STATE OF NORTH CAROLINA
DEPARTMENT OF TRANSPORTATION

April 2, 2019

Subject: Revised Application for Section 404 Individual Permit and Section 401 Water Quality Certification for the proposed Havelock Bypass in Craven County. TIP No. R-1015. WBS 34360.1.2

SEE PROJECT COMMITMENTS  
FOR SPECIAL CLEARING FOR  
-L- STA. 338+00 TO 393+00

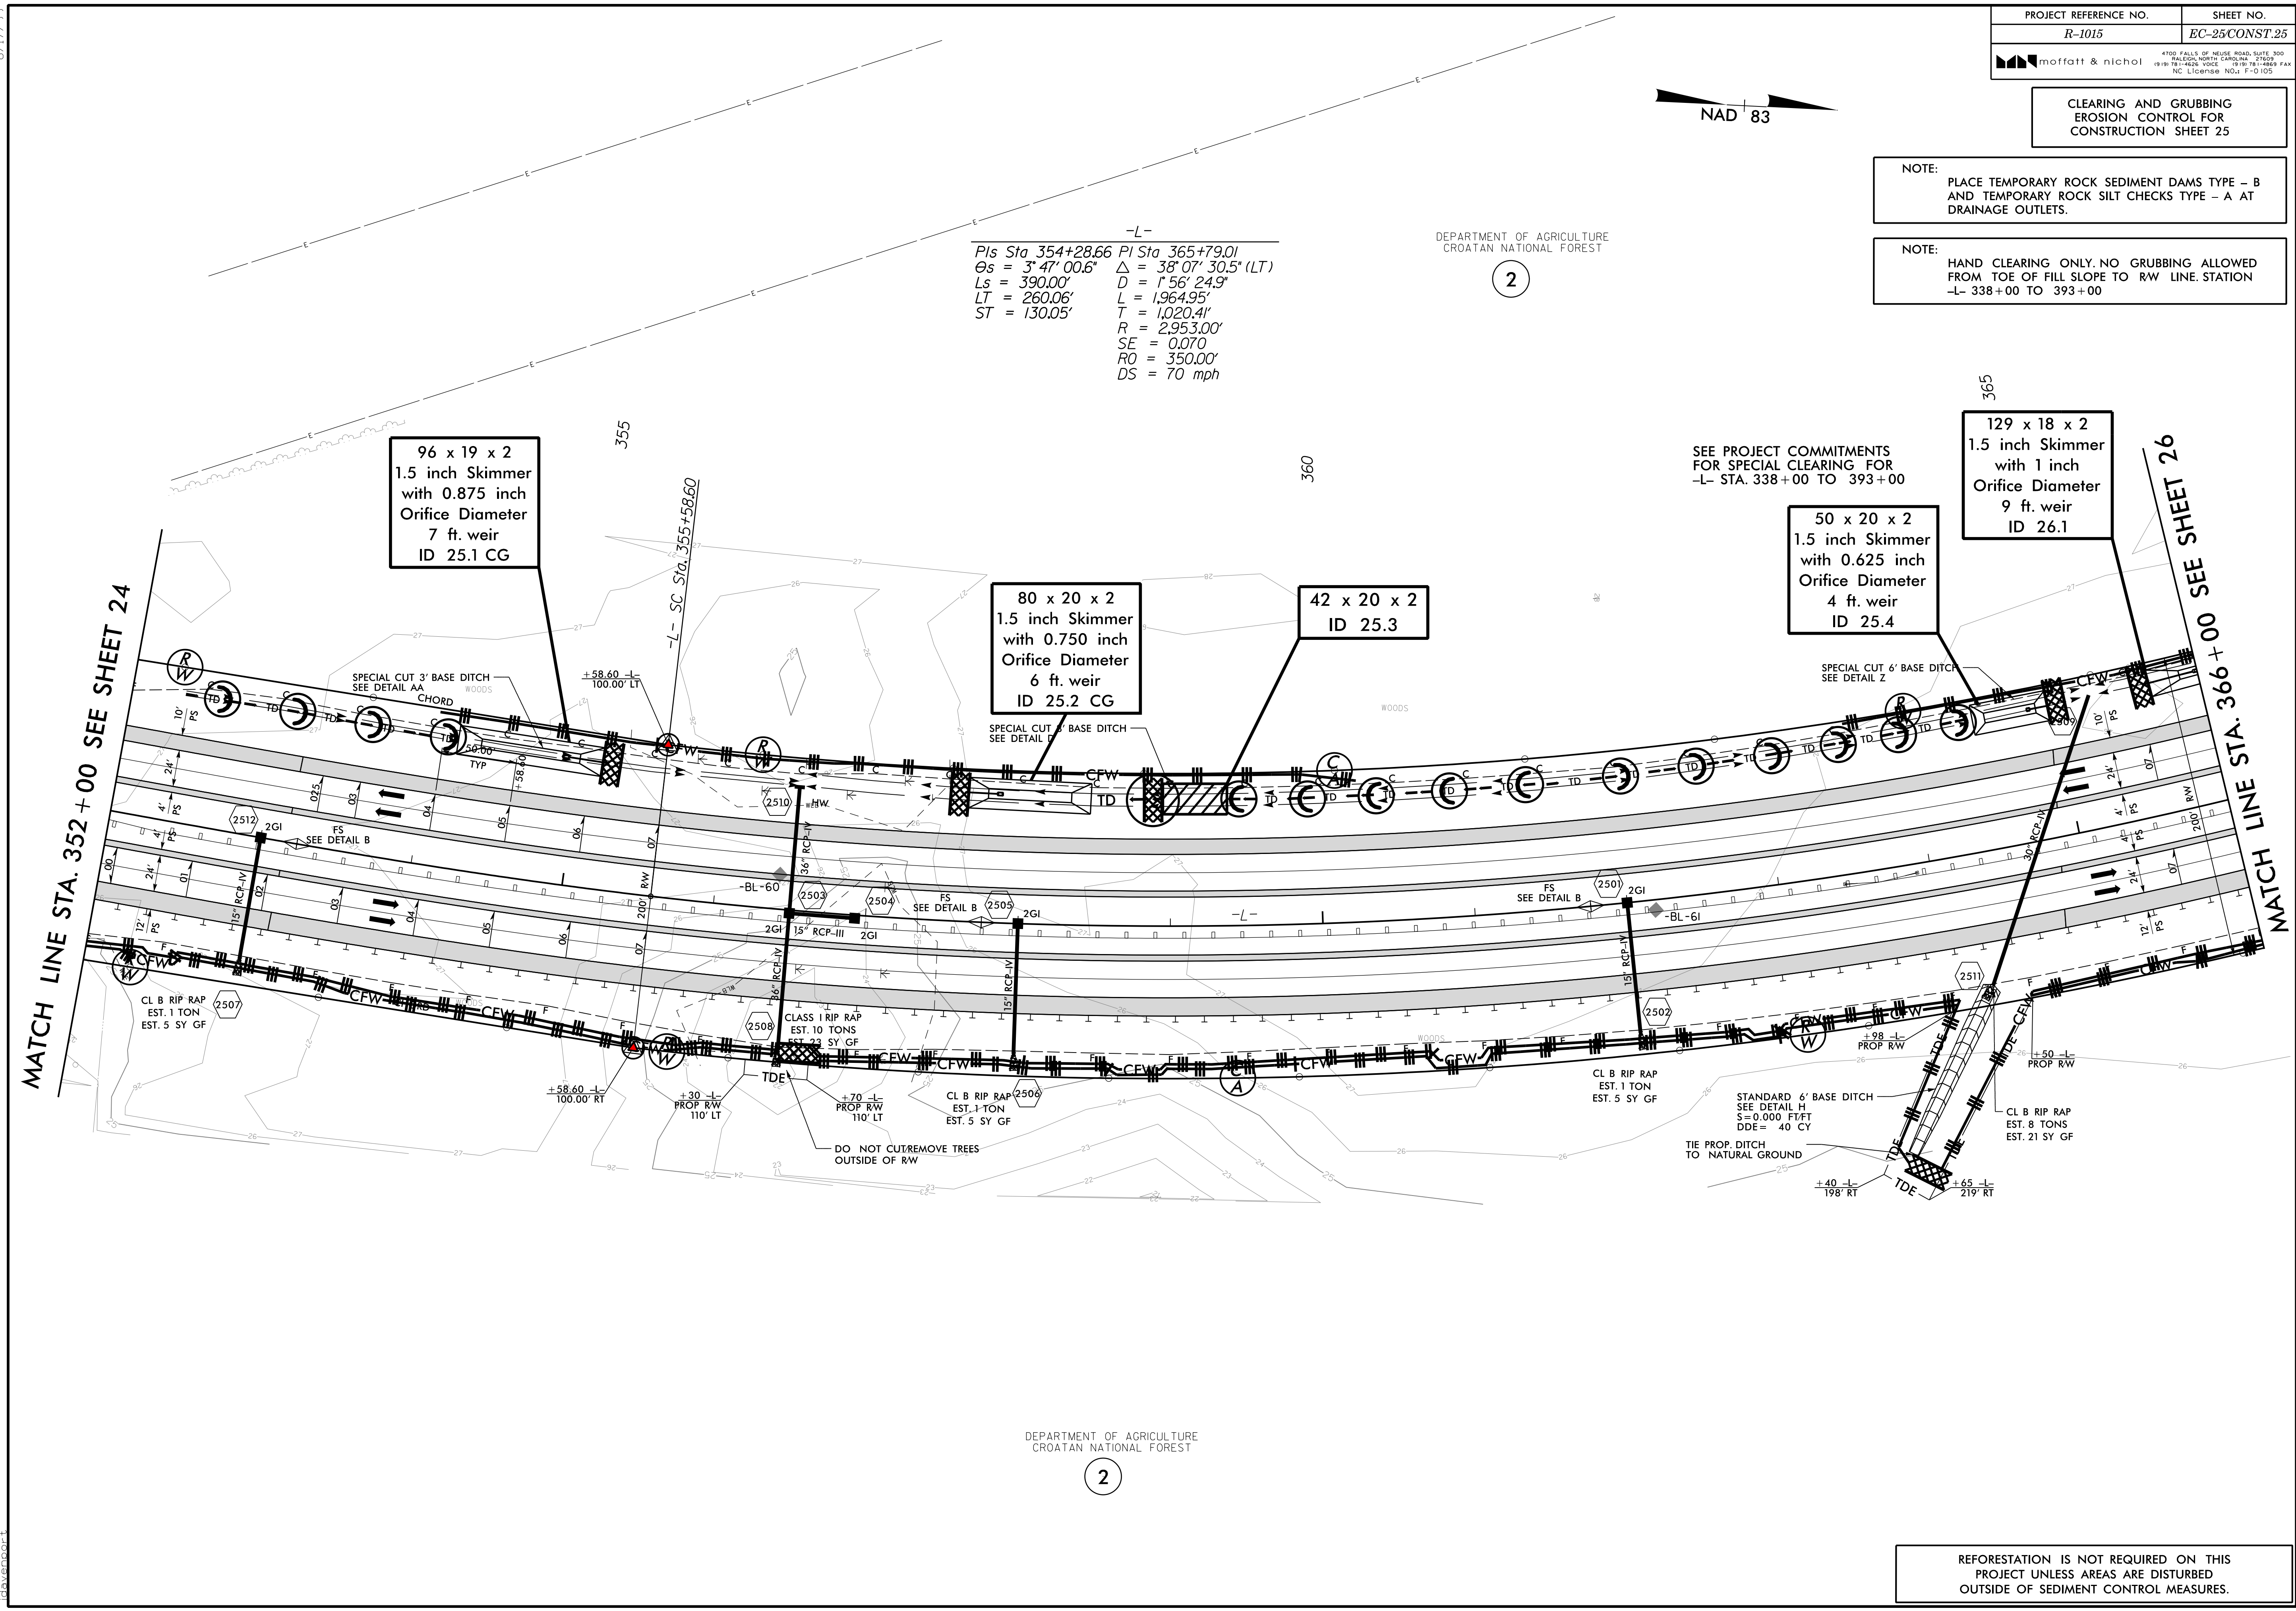
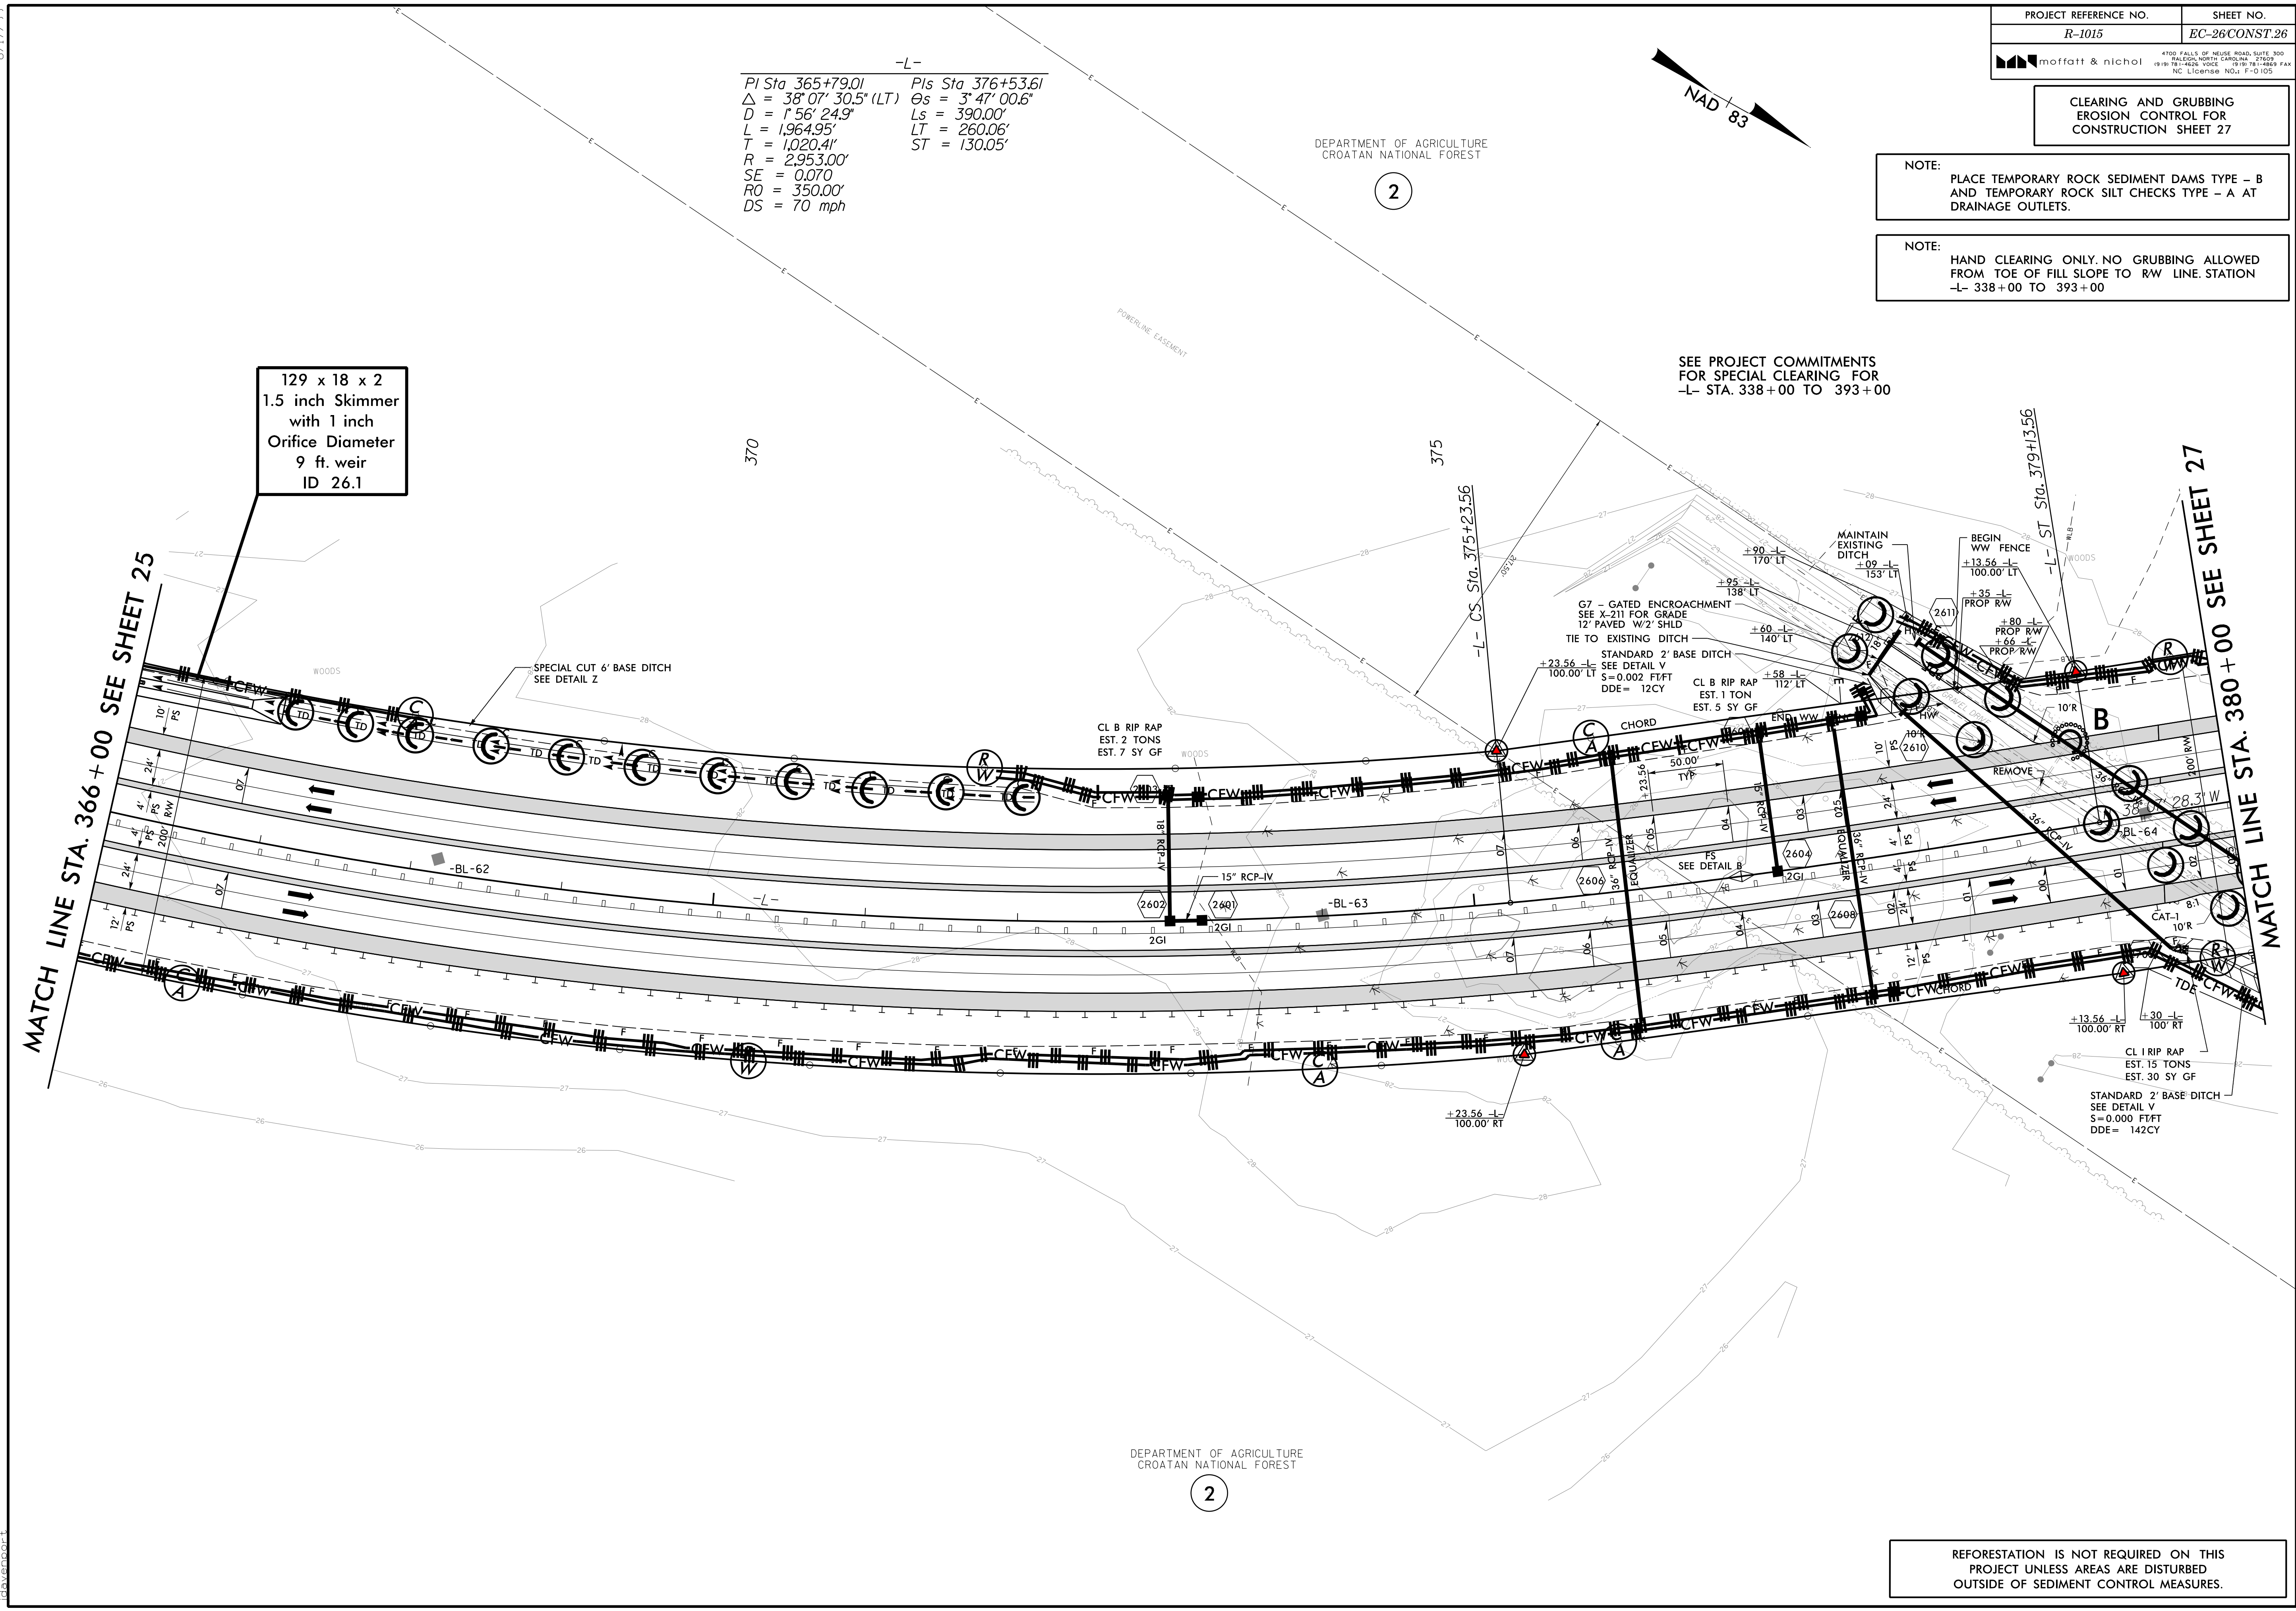
Enclosed you will find revised permit drawings for the area between stations 338+00 to 393+00. This affects permit sites 26, 27, 28A, 28B, 29, 30, and 31. The mechanized clearing shown at those sites has been changed to hand clearing. This coincides with the clearing restrictions already indicated in the erosion control plans. Revised summary sheets are also enclosed, which show the shift of 0.6 acre of wetlands clearing impacts at the affected sites from the mechanized land clearing column to the hand clearing column. As a result, the Department will reduce the proposed compensatory mitigation to correspond with this reduction in permanent impacts. A copy of the latest NC Division of Mitigation Services acceptance letter forthcoming.
